WOLLASTON PARISH COUNCIL

Formal Objection to the Green Hill Solar Farm Development Consent Order (DCO) Application

Supporting the concerns of Mears Ashby and its residents

Title: Figure 12.2.9 Archaeological Assets
Green Hill BESS and Cable Route Corridor

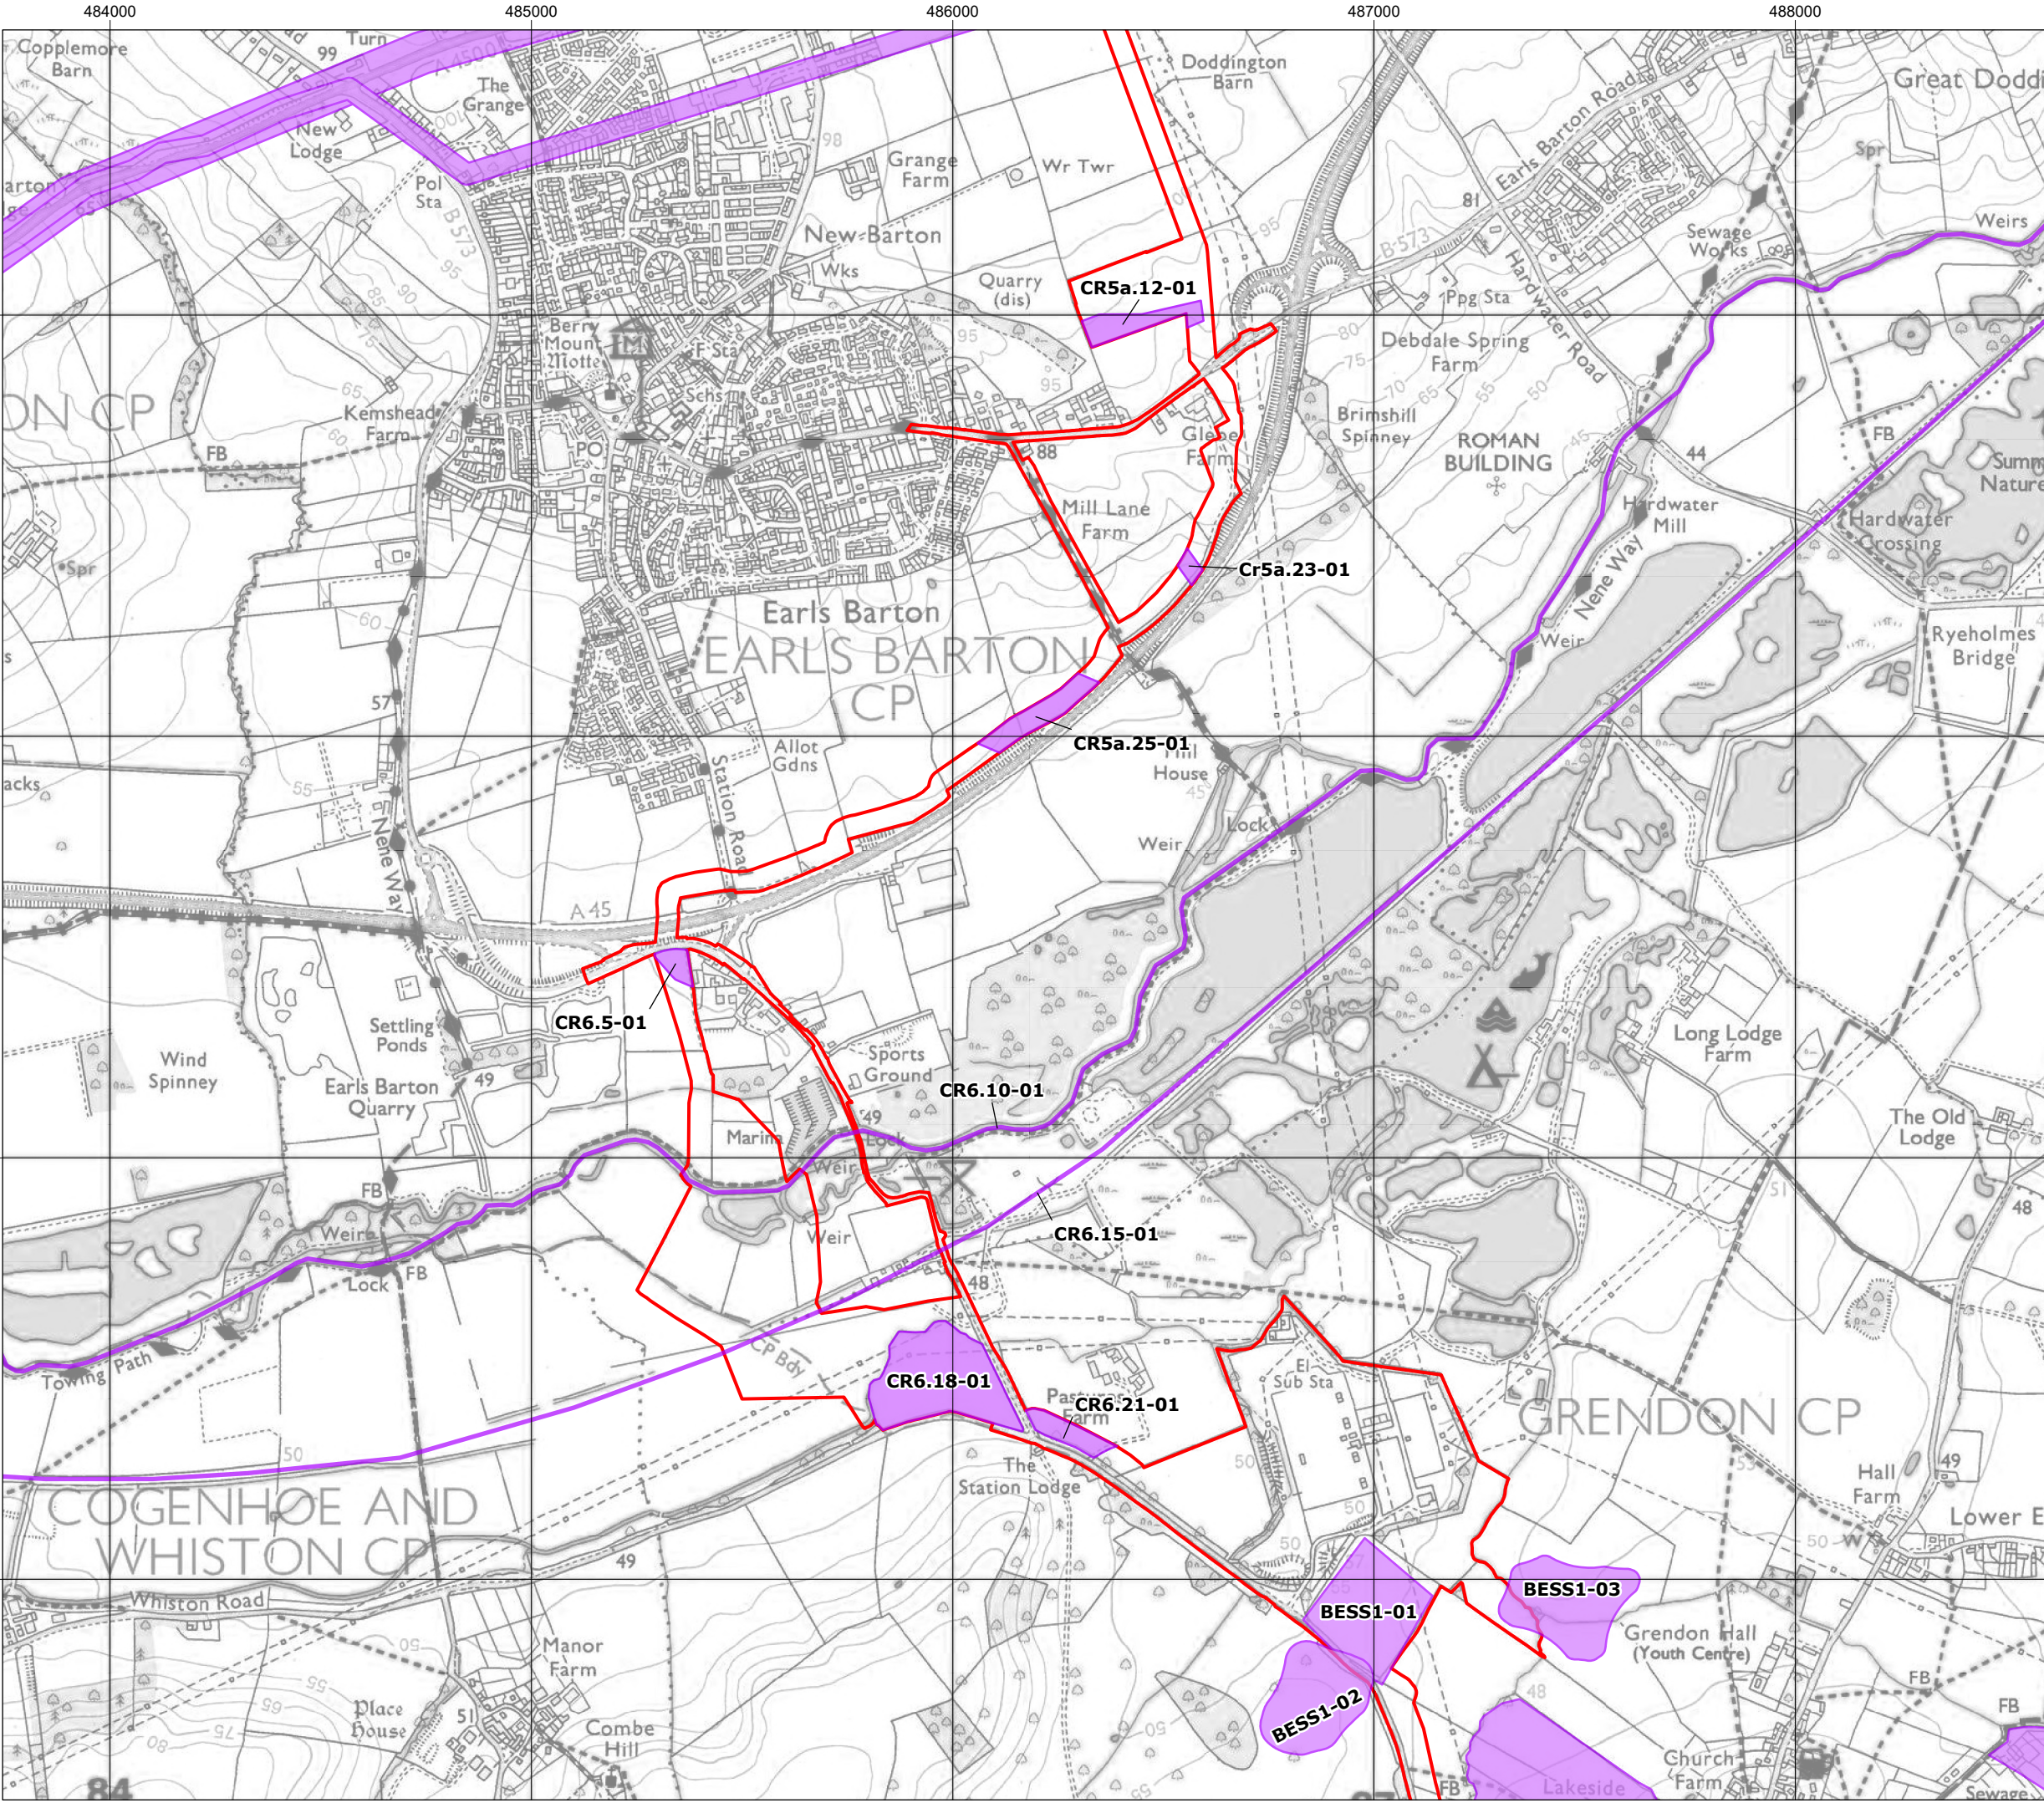
Wollaston Parish Council shares the concerns regarding the potential impact of the proposed development on the archaeological heritage of Area E, immediately east of Mears Ashby.

The archaeological investigations undertaken in connection with the Green Hill Solar Farm proposals have identified significant archaeological anomalies across Areas C, D and E, including evidence of possible prehistoric and Roman settlements, enclosures, trackways and historic field systems.

The Council is concerned that extensive construction works, including underground cable installation, foundations and associated infrastructure, could result in the disturbance or destruction of important archaeological remains.

The Council requests that the applicant demonstrates that the archaeological significance of Area E has been fully assessed and that appropriate measures are in place to avoid or minimise harm.

Where preservation in situ is possible, this should be prioritised. Any proposed archaeological investigation or recording should be proportionate to the significance of the remains and supported by an appropriate, enforceable mitigation strategy.

Title:
Figure 13.21: AIL Routes to Solar and BESS Sites (Sites: Green Hill A, B, C, E)

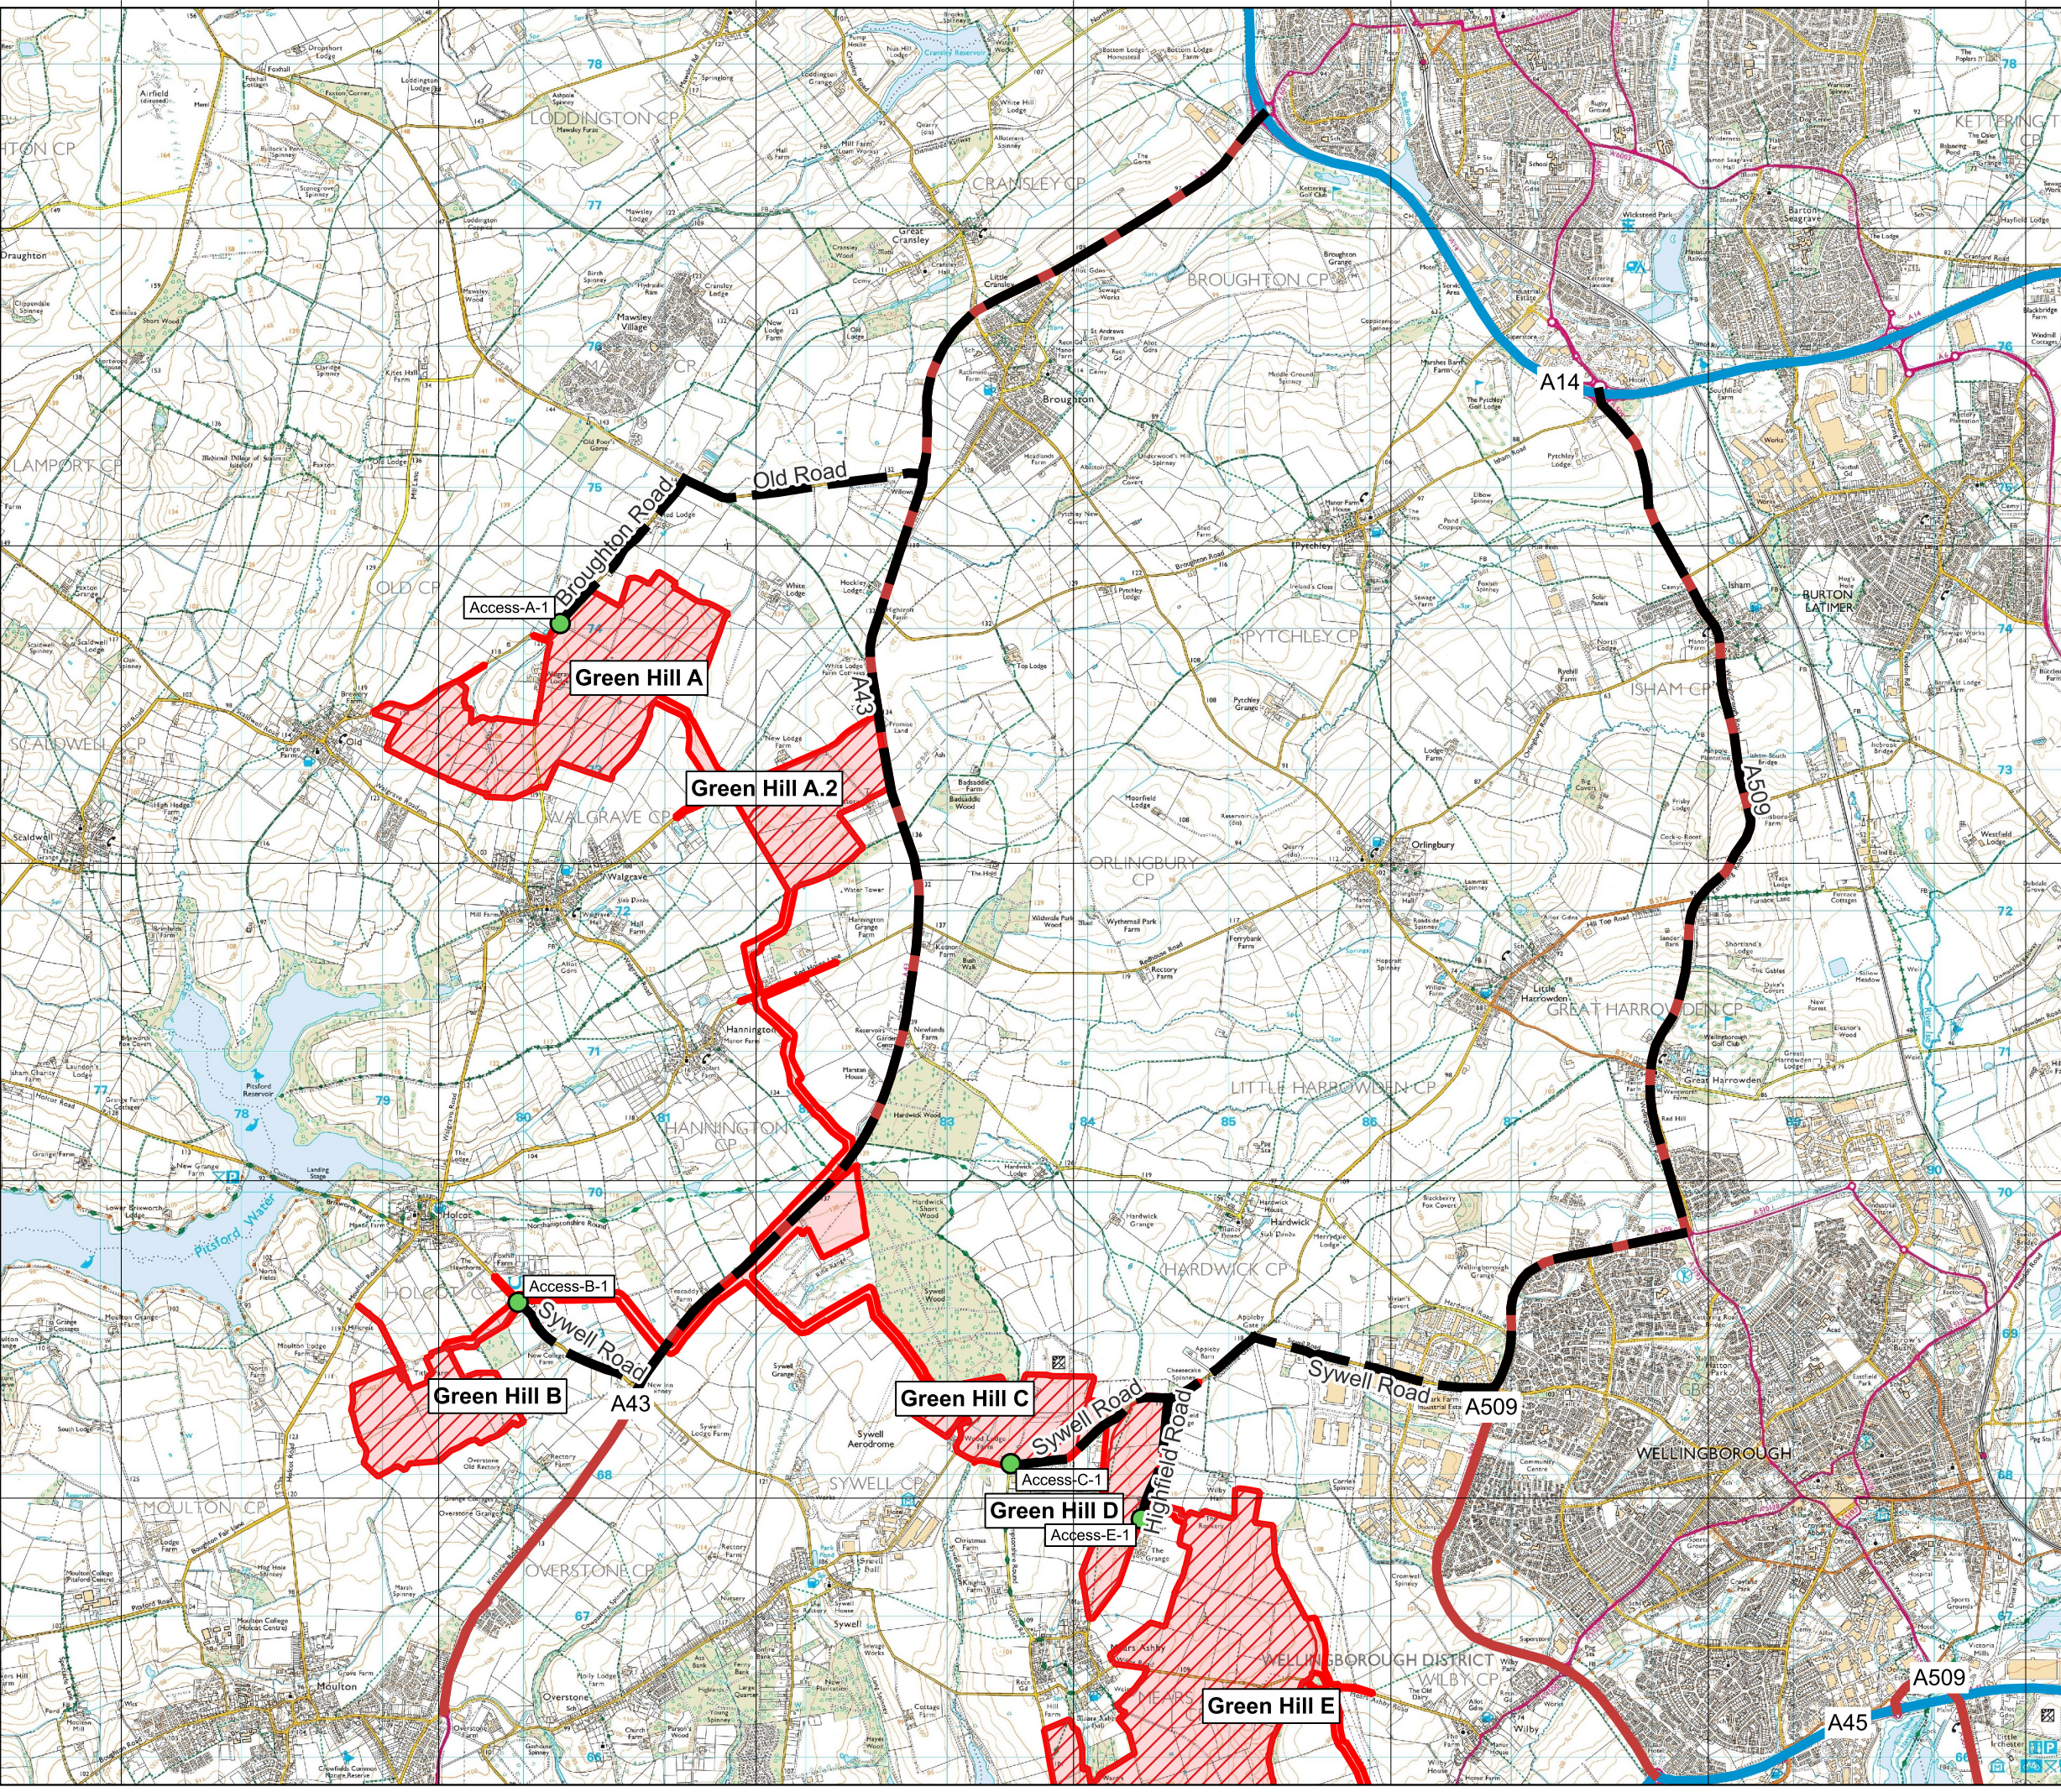
Wollaston Parish Council is concerned about the potential impact of construction traffic associated with the development on the rural highway network surrounding Mears Ashby.

Particular concern is raised regarding Wilby Road, which is understood to include narrow sections, restricted visibility and bends that may present challenges for large construction vehicles.

The Council is concerned that increased HGV movements could create additional hazards for existing road users, including pedestrians, cyclists, horse riders and residents accessing nearby properties.

The Council requests that the applicant provides a comprehensive assessment of the proposed construction traffic routes, including the suitability of Wilby Road for the anticipated volume and size of HGVs.

The Council also requests that consideration is given to alternative construction access arrangements where these would reduce impacts on Mears Ashby and neighbouring communities.

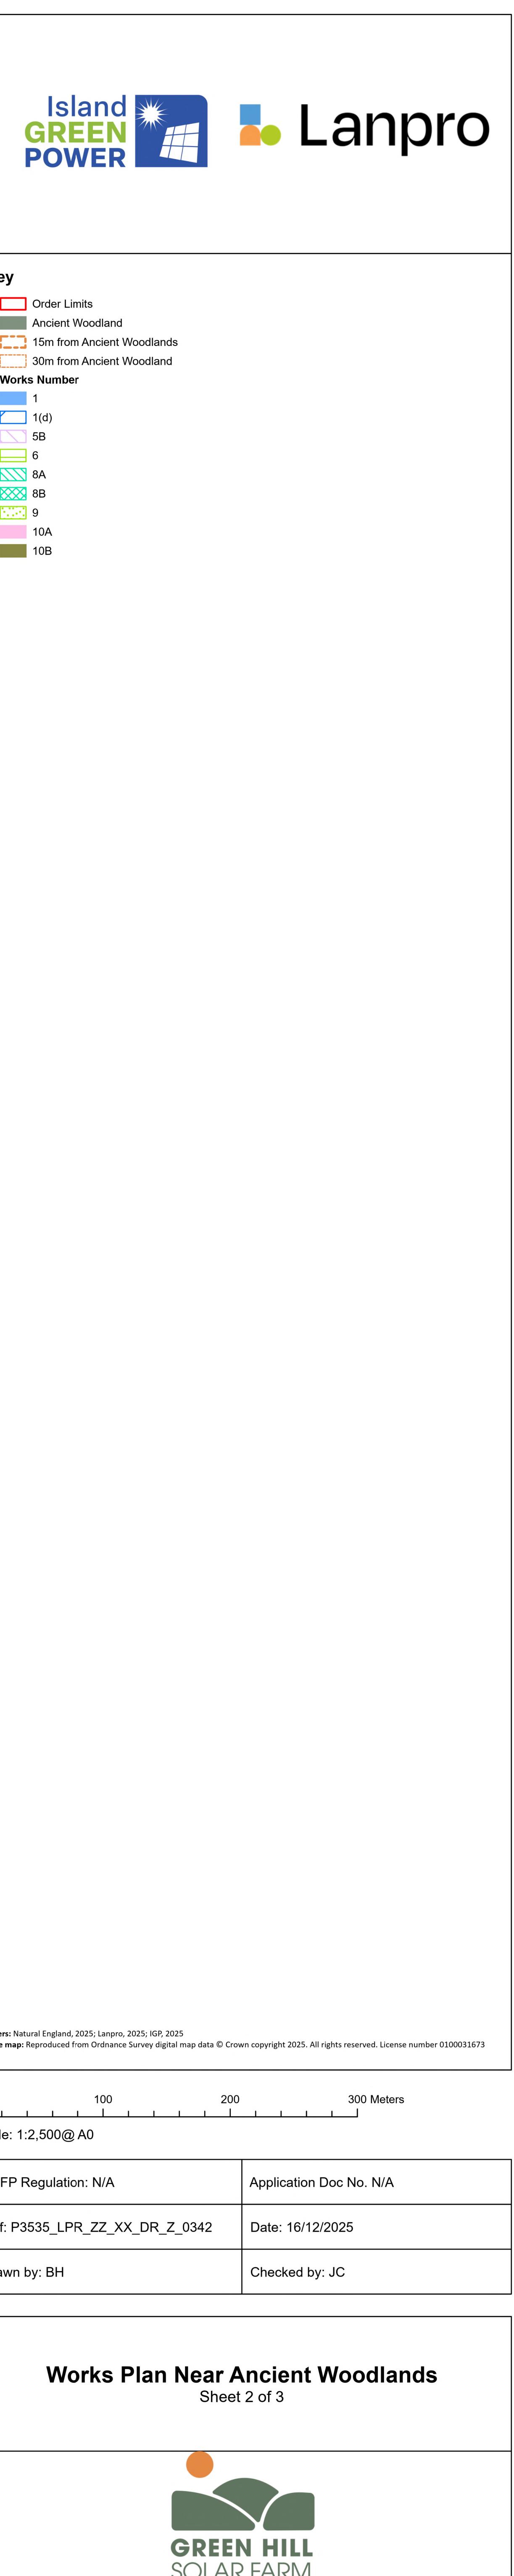
Wollaston Parish Council is concerned about the proposed 9.2-acre Battery Energy Storage System (BESS) facility in close proximity to Sywell Wood, an area of ancient woodland.

The Council is concerned that the construction and operation of a large-scale industrial battery storage facility immediately adjacent to this woodland could adversely affect its ecological integrity, including through construction disturbance, changes to drainage and hydrology, and potential impacts on established habitats and wildlife.

The Council requests that the potential effects on Sywell Wood are fully assessed and that the applicant demonstrates how the woodland and its associated ecological environment would be protected from direct and indirect harm.
